Our ref: Dalswinton Sand and Gravel Quarry (SSD-9094)

Subject: Request for Additional Information

I refer to the Environmental Impact Statement (EIS) and Response to Submissions (RtS) for the Dalswinton Sand and Gravel Quarry (SSD-9094).

EIS Figure 2: History of Site Operations

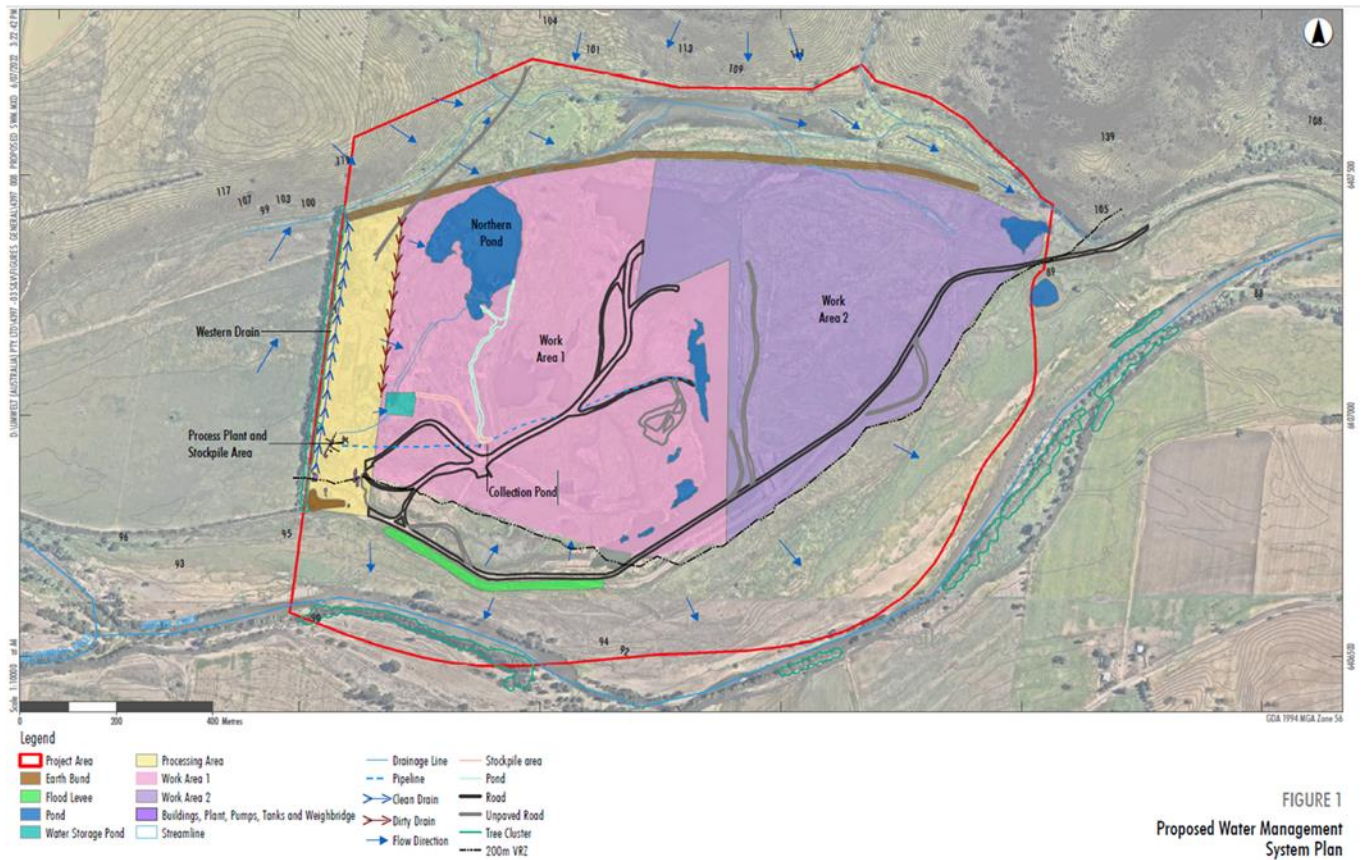
- distance to the closest dwelling (EIS states 600m, RTS states 1.1km); and
- disturbance boundary and project boundary (see Attachment B).
